**DELEGATED DECISION TO DETERMINE APPLICATIONS FOR
NON-MATERIAL AMENDMENTS**

Reference No: 2021/NM/90819/E

Site Address: Land south-east of, Abbey Road, Shepley,
Huddersfield, HD8 8FG

Description: Non-material amendment to previous permission ref:
2019/91569 for erection of 31 dwellings

HOUSE TYPE C2 - PLOTS 4 & 31
1914-HT-C2-01 REV. D
ABBAY ROAD, SHEPLEY
YORKSHIRE COUNTRY PROPERTIES
SCALE:1:100@A3 - MAY 2019

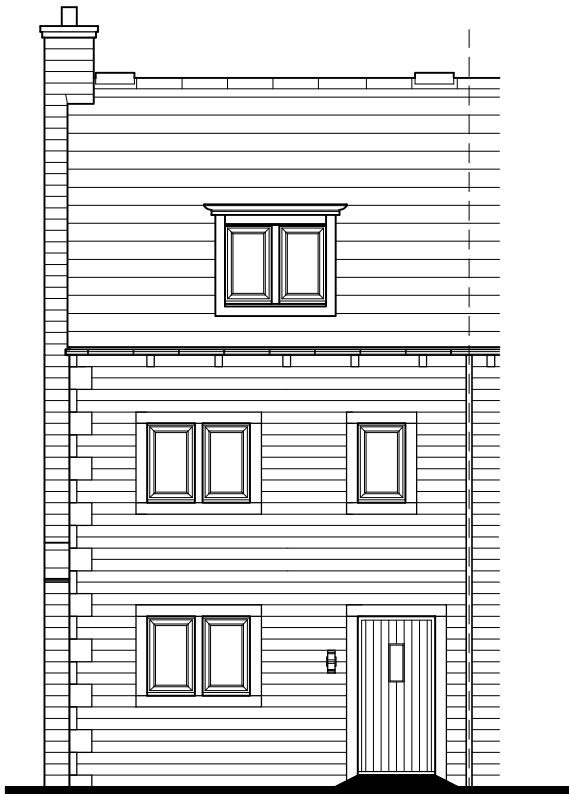
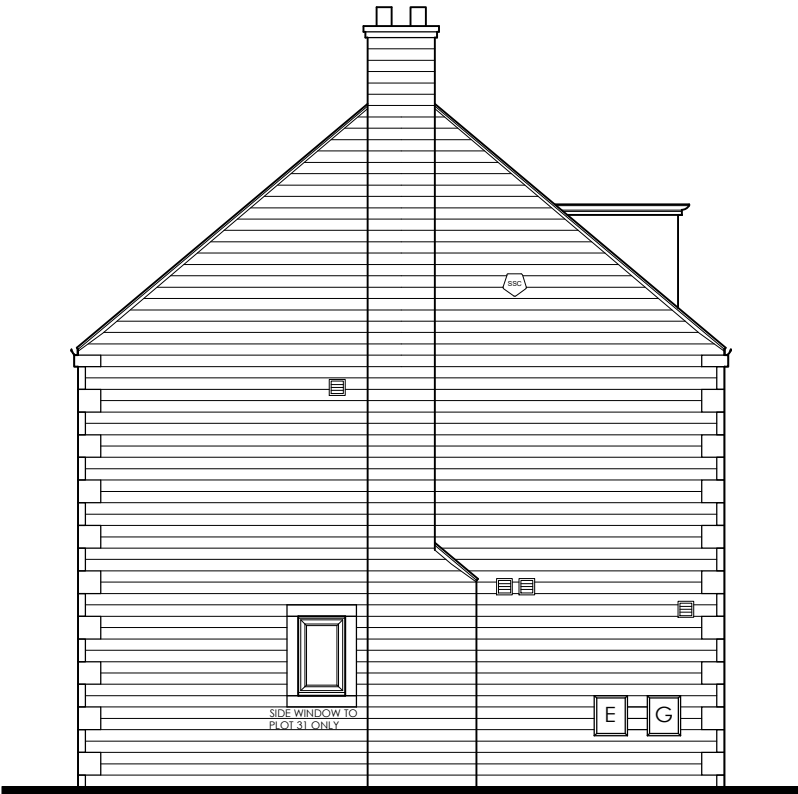
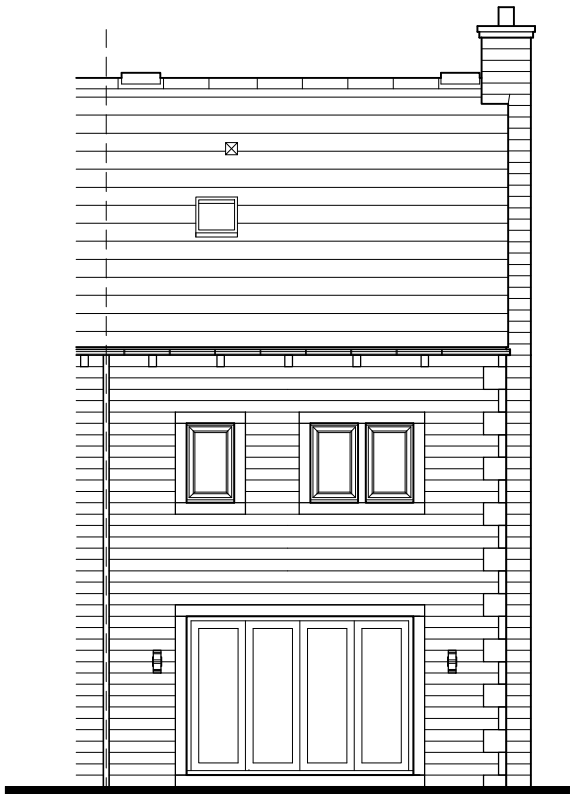
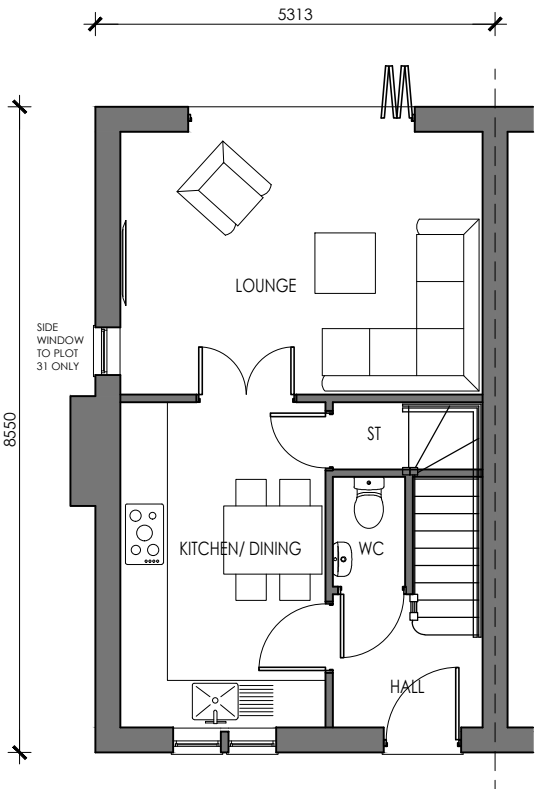
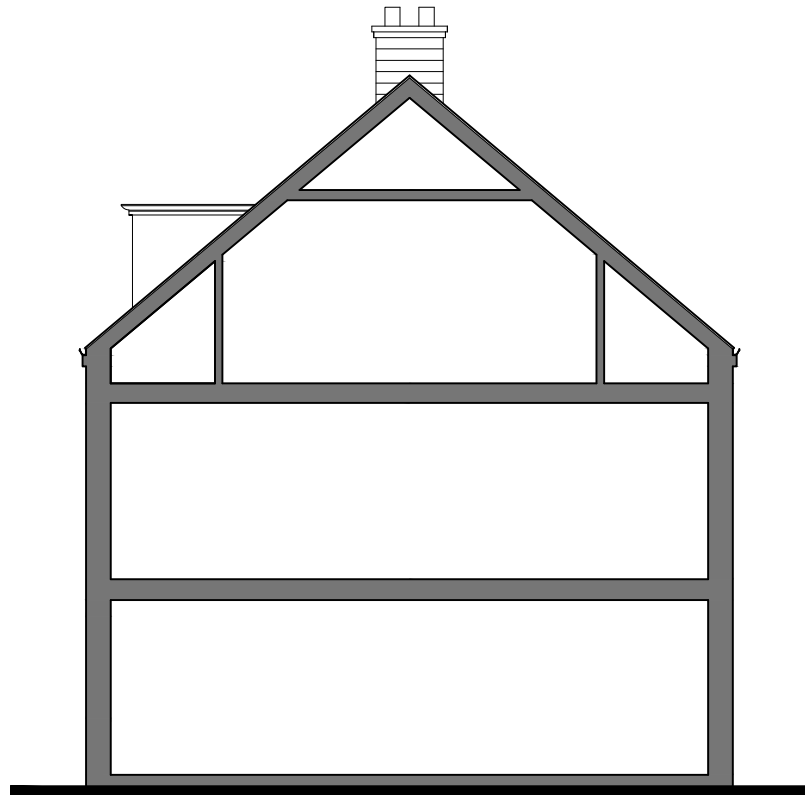
- Window at front elevation (ground floor level) reduced from three lights to two (units 3, 4, 14, 15, 29, 30 and 31).
- Window and French doors at rear elevation (ground floor level) replaced with folding doors (units 3, 4, 14, 15, 29, 30 and 31).
- Ground floor window deleted from side elevation (units 3, 14, 15, 29 and 30).
- Ground floor window relocated along side elevation (units 4 and 31).
- Projecting side elevation chimney deleted (units 3, 14, 15, 29 and 30).
- Meter boxes, alarm box, vents and external lighting shown on elevations (units 3, 4, 14, 15, 29, 30 and 31).
- Coping and kneelers added to gable ends (units 14 and 15).

- 1914-HT-C2-01 rev D (plans and elevations for units 4 and 31).
- 1914-HT-C2-02 rev B (plans and elevations for units 14 and 15).
- 1914-HT-C2-03 rev A (plans and elevations for units 3, 29 and 30).
